Alan Varela, Director

March 17, 2023

**Re: Carlisle Crossing Main Building Permit - 2100 Carlisle Blvd NE
Erosion and Sediment Control Plan
Engineer's Stamp Date 3/6/2023 (H17E097)**

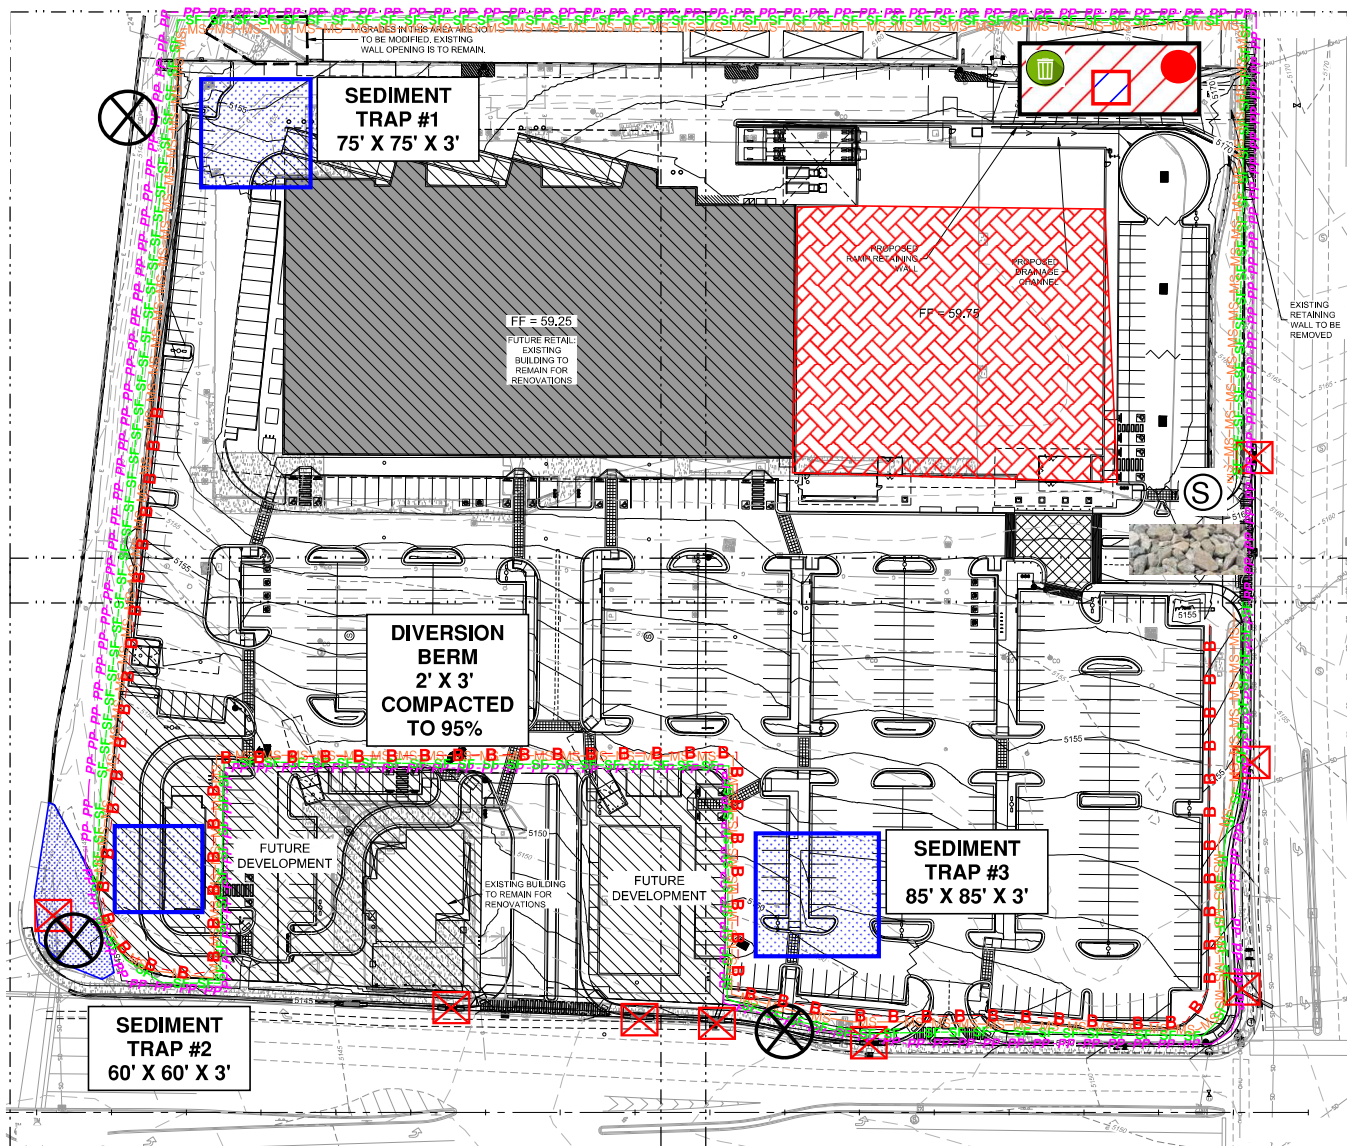
3. An accurate map of existing conditions is required. Show the Limits of Land Disturbance around all remaining areas of disturbance and any new areas to be graded this project. Specify stabilization per CGP 2.2.14. for all disturbed areas. The limits are currently shown around the entire site most of which is covered by existing structures (building, paving, and sidewalk) to remain. Staging areas should be identified separately from disturbed areas that require stabilization.

4. Show on-site drainage patterns of stormwater per CGP 7.2.4.f. Identify locations of concentrated flow paths and that enter and exit the disturbed areas. Identify locations where sheet flow enters and exits the disturbed areas. Either divert flows from existing impervious areas around the disturbed areas or specify stabilization sufficient to prevent erosion in the disturbed areas per CGP 2.2.14.

SHEET NUMBER: C-100

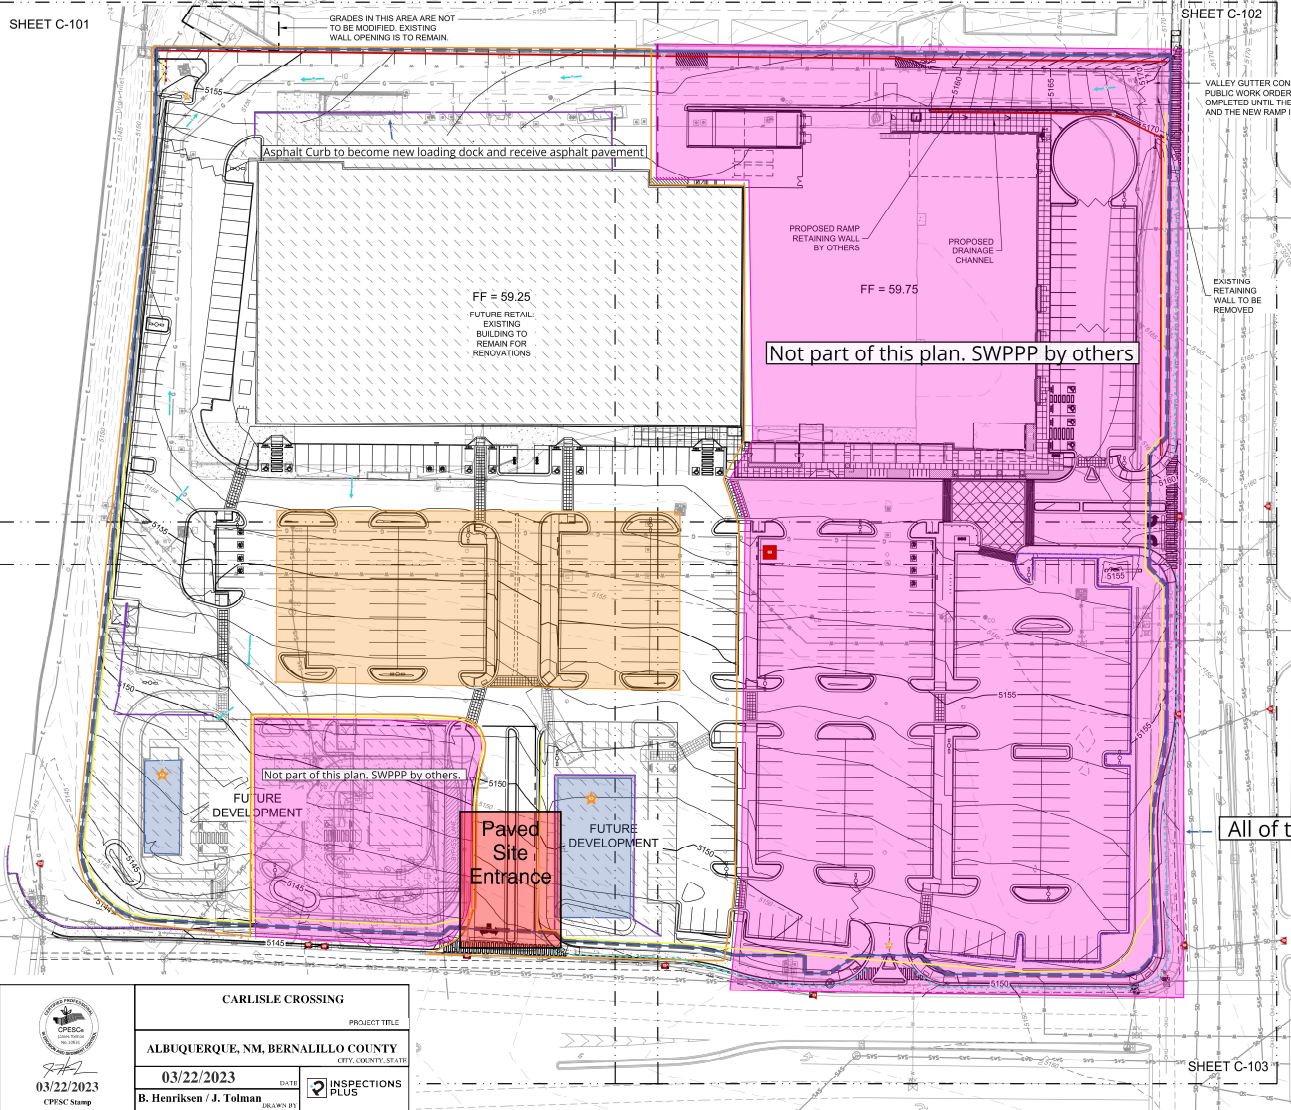
1. You must provide the property owner's NOI per Albuquerque Code § 14-5-2-11(a). The property owner's NOI, ID# NMR10040K, expired a year ago.
2. The Stormwater Quality section can't approved the ESC Plan for Building Permit until after Hydrology approves a Grading and Drainage Plan for Building Permit. It appears that the owner and his engineer failed to address the Hydrology comments dated 12/6/2019(attached). The existing and proposed grades must be shown on the ESC Plan (CGP7.2.4.b.ii), but they are missing from the submitted plan. You should only show proposed grades in areas you will grade under this permit, not in areas already graded. Grades shown on the ESC Plan must agree with the grades on the plan approved by Hydrology.
